Consultation Response from KC, Conservation and Design**2022/90425 & 2022/90426 Bates Mill, Queen Street South, Huddersfield, HD1 3DX****Advertisement consent for 1 no. non-illuminated projecting sign [Listed Building] &****Listed Building Consent for 1 no. non-illuminated suspended sign****Date Responded: 17.03.2022****Responding Officer: Sebastian Pickles****Responding Ref:**

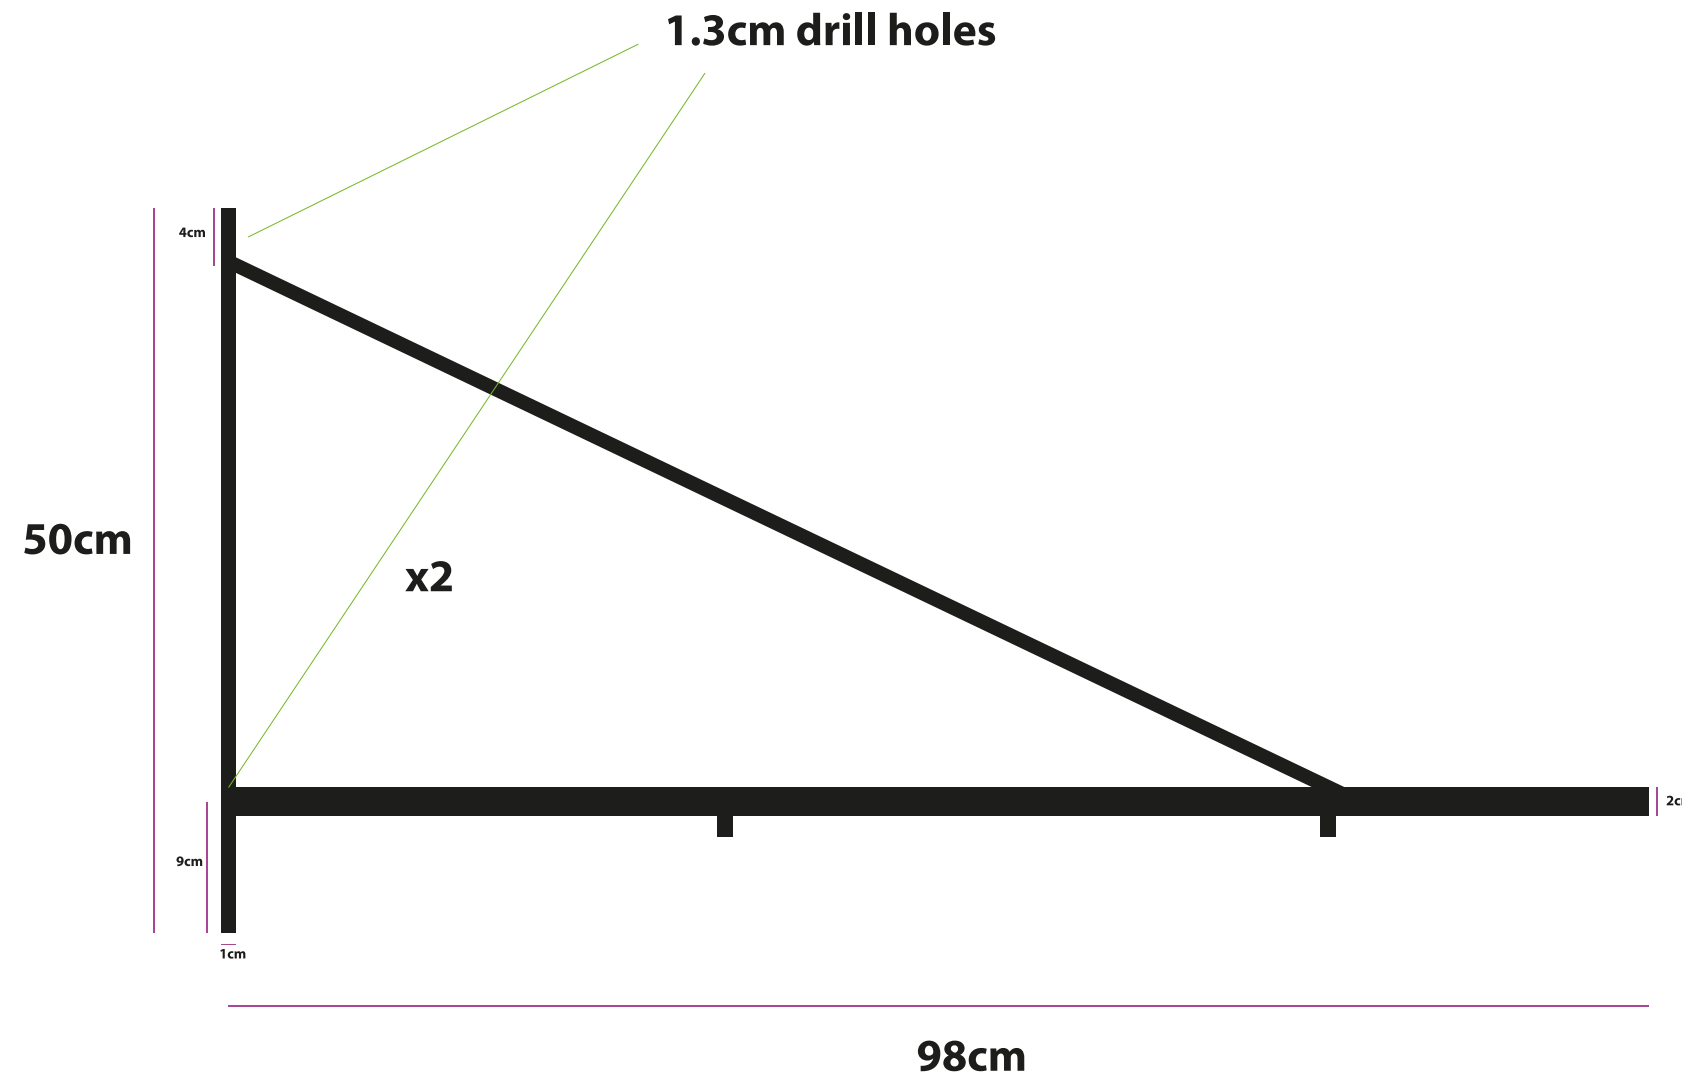
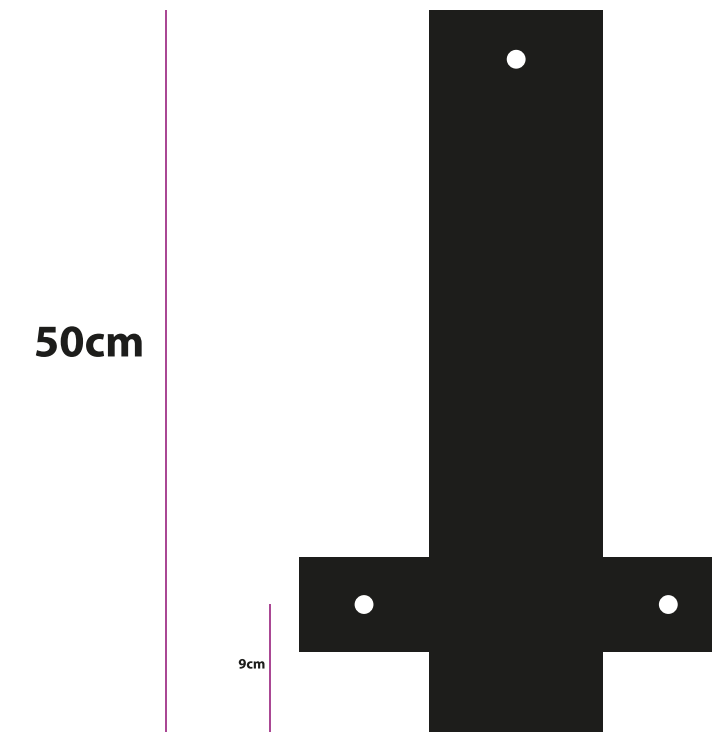
Having reviewed the submitted detail, Conservation and Design would not raise any objections to the proposed hanging sign. We consider that it would be more appropriate for the sign to be painted timber with a border, however on balance the proposed sign will not have a significant impact on the character and significance of the Listed Mill or the Conservation Area.
